Response to Planning Application

Application ref: LU/246/24/PL

Description: Demolition of existing structures and development of land to create 10 No. residential dwellings, landscaping, access, car parking and cycle parking. This application may affect the setting of listed buildings, is in CIL zone 2 and is CIL liable as new dwellings.

Location: Land at Toddington Lane Littlehampton BN17 7PN

**Figure 1.** Proposed landscaping plan for the development at Land at Toddington Lane, reproduced from Studio gb, dated September 2024 (drawing no. TLN-SGB-00-GF-DR-L-101).

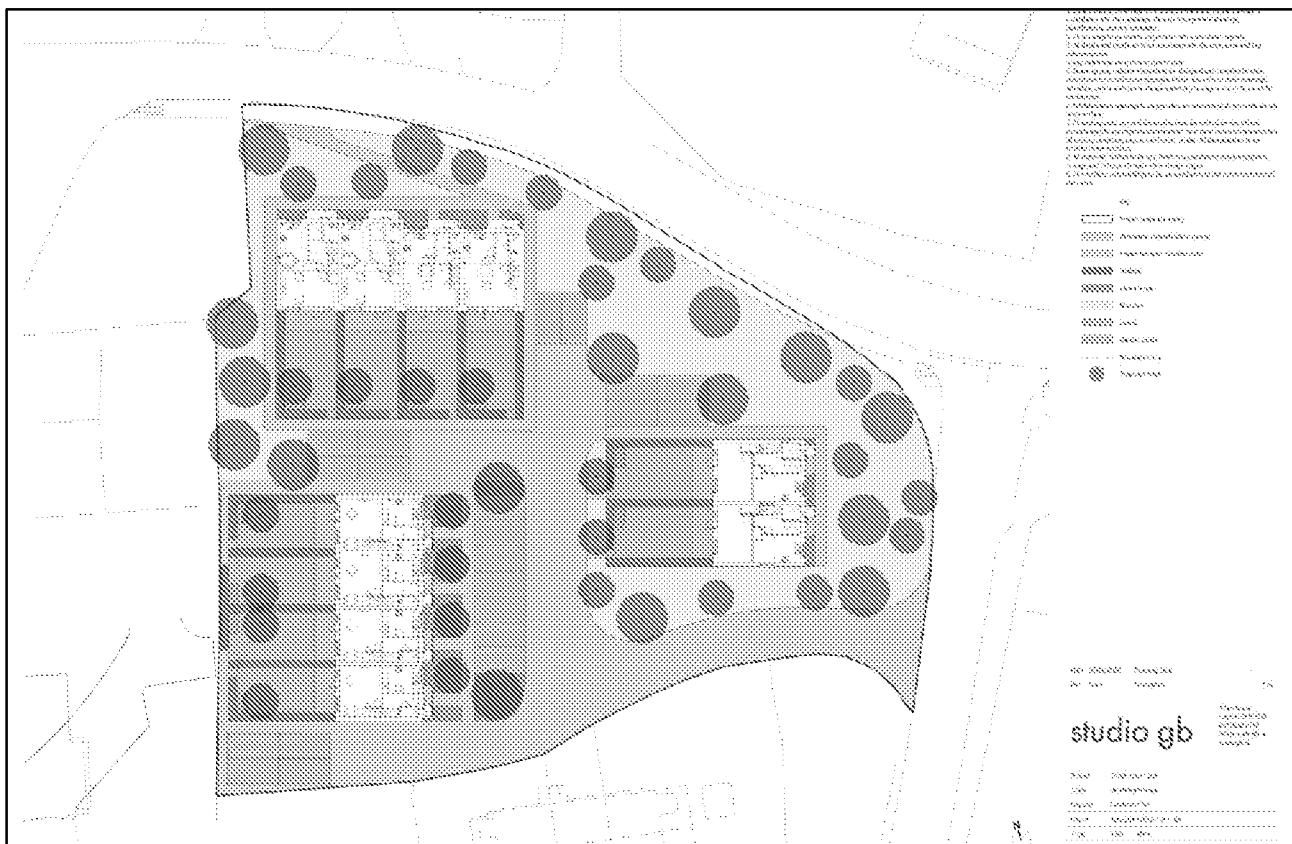
A site plan, Landscape GA L-101, Planting strategy, Landscape Statement and Design and Access statement have been submitted. The detail provided within these drawings is indicative only and would require further landscape drawings to detail actual quantities, planting densities and size at time of planting.

LAP provision is not indicated on the plans and would be a requirement, which would need to be shown. Location of the indicated open area surrounding the semi-detached plots is banked or adjacent to a roadway and therefore may not be suitable location for LAP provision.

It is noted that much of the green infrastructure proposed is located within private garden locations, with trees and hedges which have the potential to be removed by the residents and therefore not a guaranteed long stay of the scheme. This in turn will effect Biodiversity Net Gain calculations. Green infrastructure proposals should be included within the site outside of private dwelling remits.

The landscape scheme submitted within the DAS is indicative only and will require plan submission of proposals to include quantities, species choice, position, densities and size at time of planting. This detail is required in plan and list form and in relation to existing trees and vegetation retained in order to give a clear and adequate picture of the proposals..
